***MODIFICATION REQUEST:
Hurstville Private Hospital
37 Gloucester Road, Hurstville
(MP 11_0042 MOD 2)***

Modification to the internal layout, changes to the façade, increase in height of the lift shaft and expanded plant area on the rooftop

Secretary's Environmental Assessment Report
Section 75W of the *Environmental Planning and
Assessment Act 1979*

December 2014

VIEW 6: PERSPECTIVE FROM REAR OF 10 MILLET ST - MOD 2

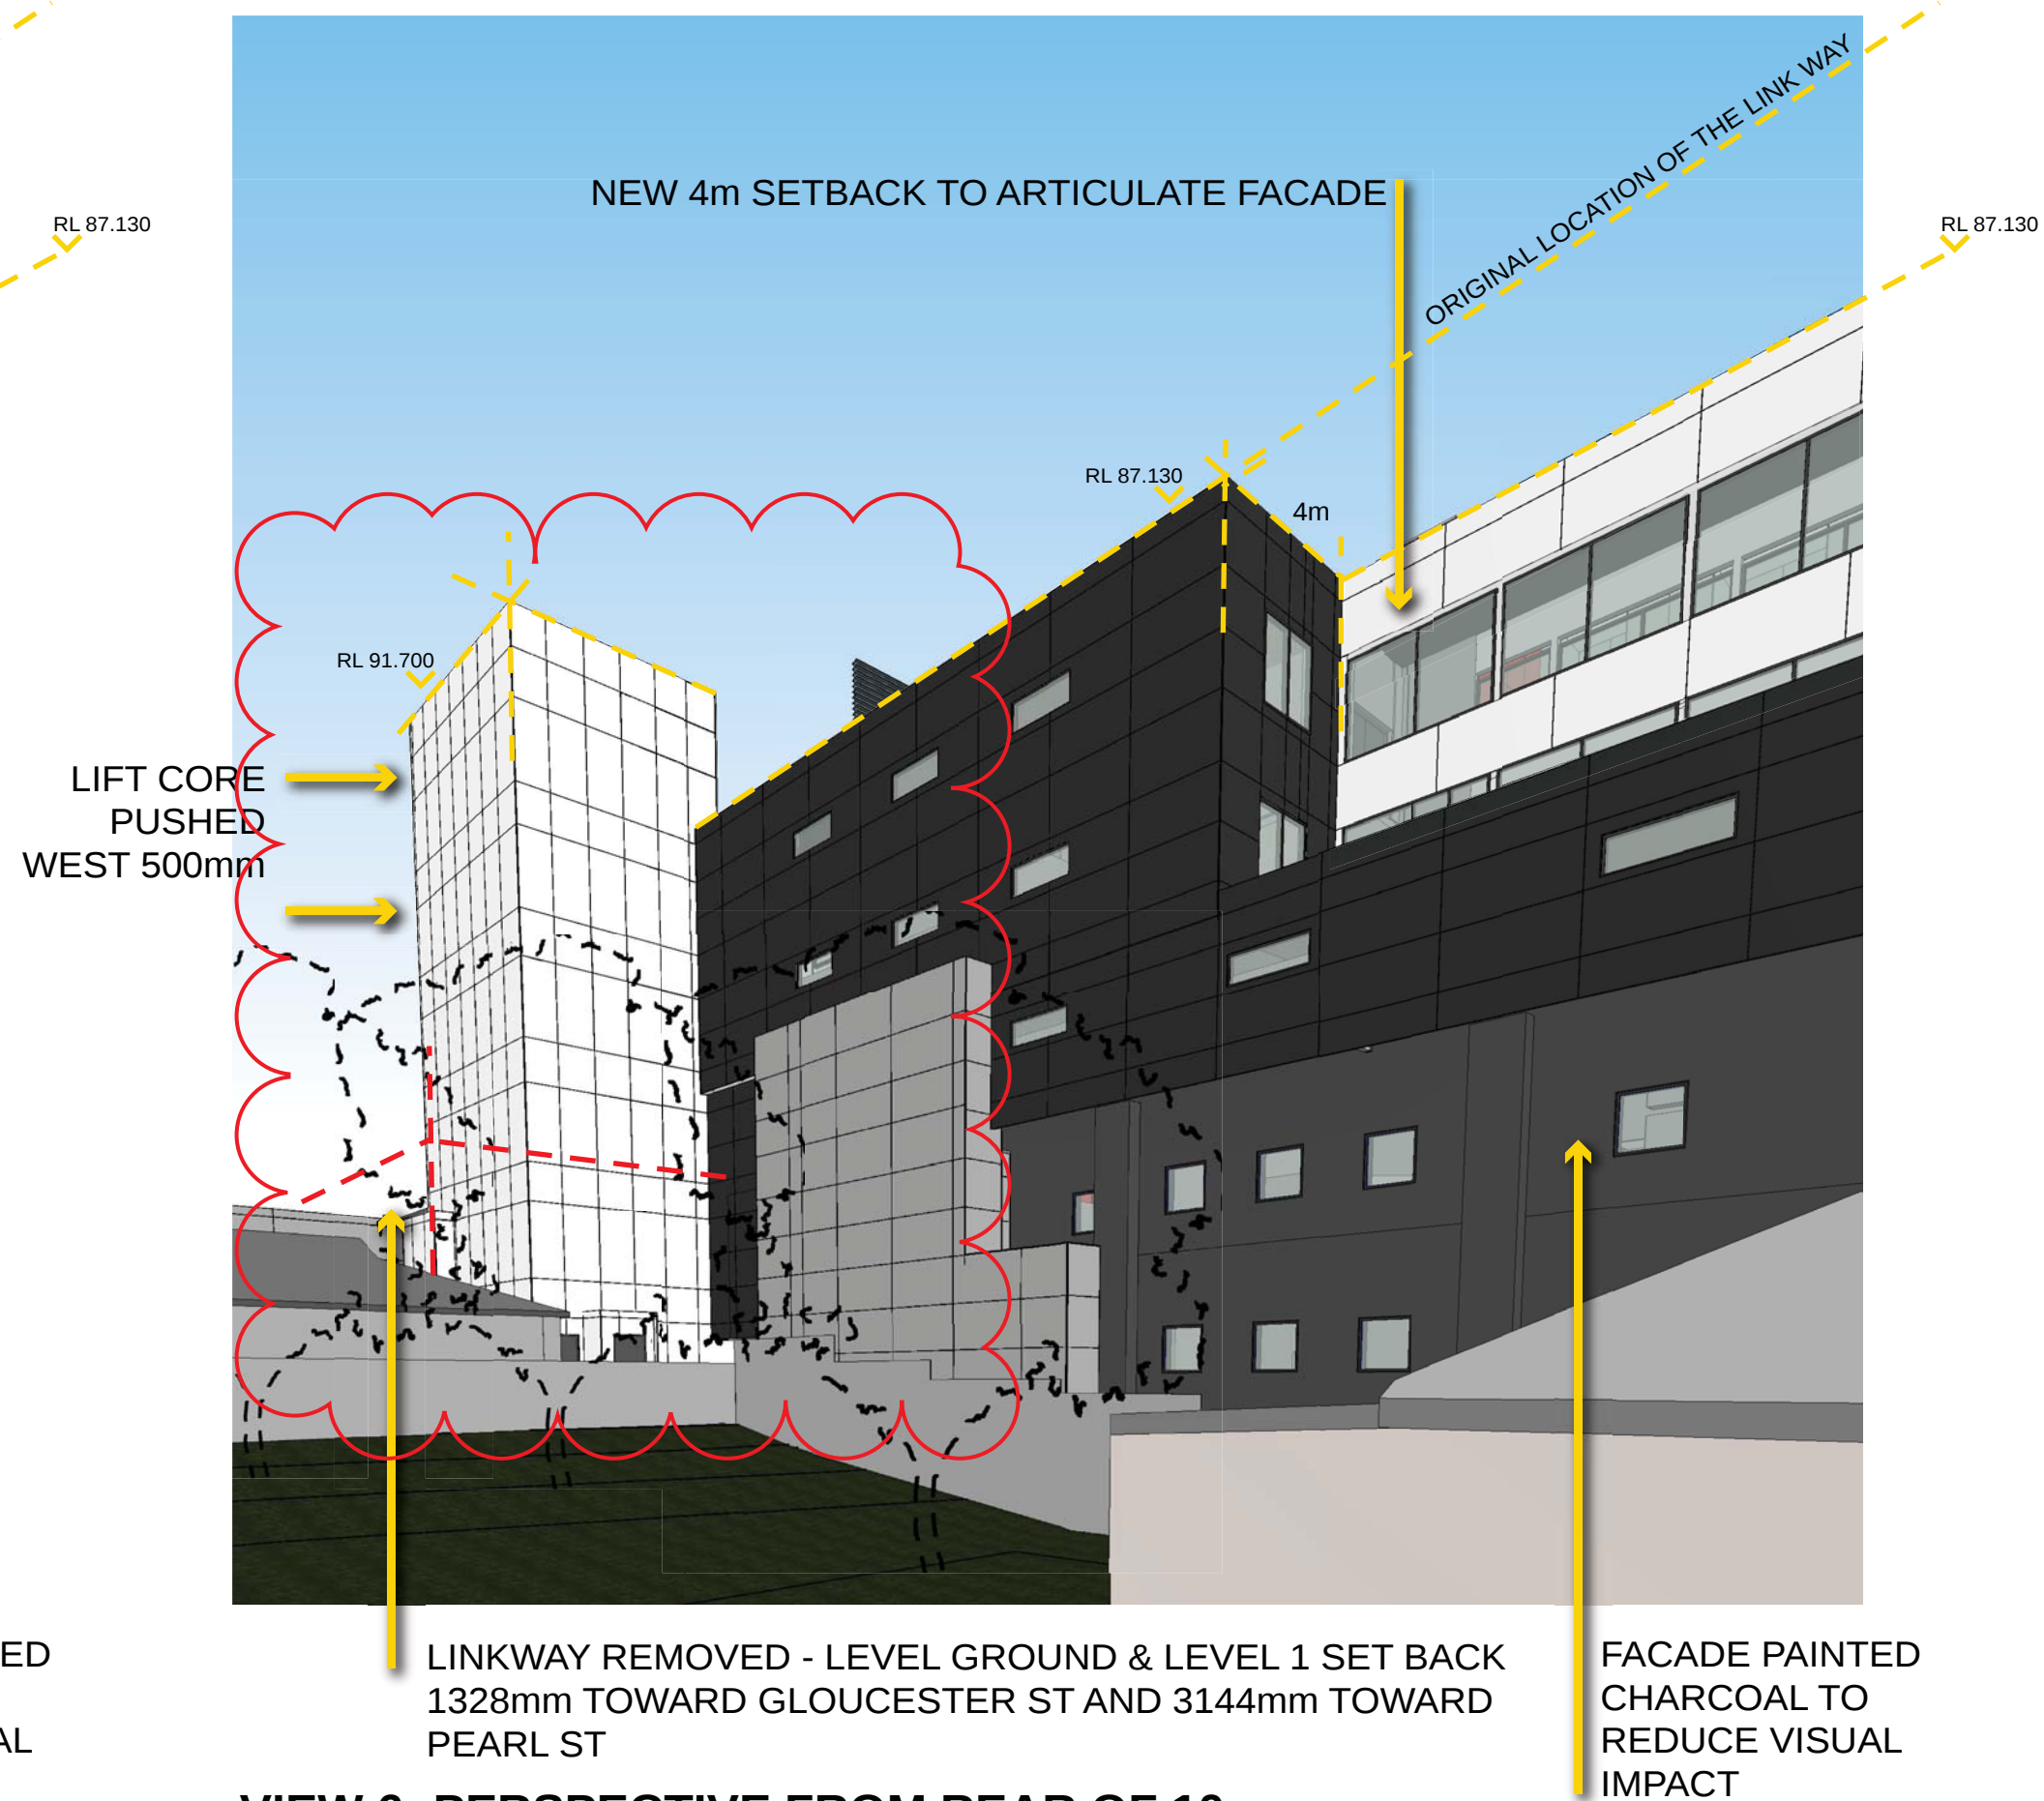
The additional height associated with the lift core also has the potential to adversely impact on the amenity currently enjoyed by the adjoining low scale residential properties directly to the south-west, fronting onto Millett Street. The proposed additional height would be readily visible above the parapet of the main building from these properties. However, the additional height would be offset by the removal of the link-way at the base of the lift core (as a consequence of the link corridor being relocated to the Gloucester Road side of the core), which would introduce a more slender building form (see **Figure 4**). The additional height associated with the lift overrun would also introduce some articulation to the roof line and assist in breaking up the mass of the building when viewed from the rear of the adjacent residential properties. Shadow diagrams submitted with the modification application demonstrate that there will be negligible additional shadow impacts on the rear of residential properties in Millett Street.

The Department is satisfied that reasonable access to sunlight and ventilation would be maintained to adjoining residential properties, and in the absence of any amenity impacts, concludes that the visual impact associated with the additional height of the lift parapet is reasonable.
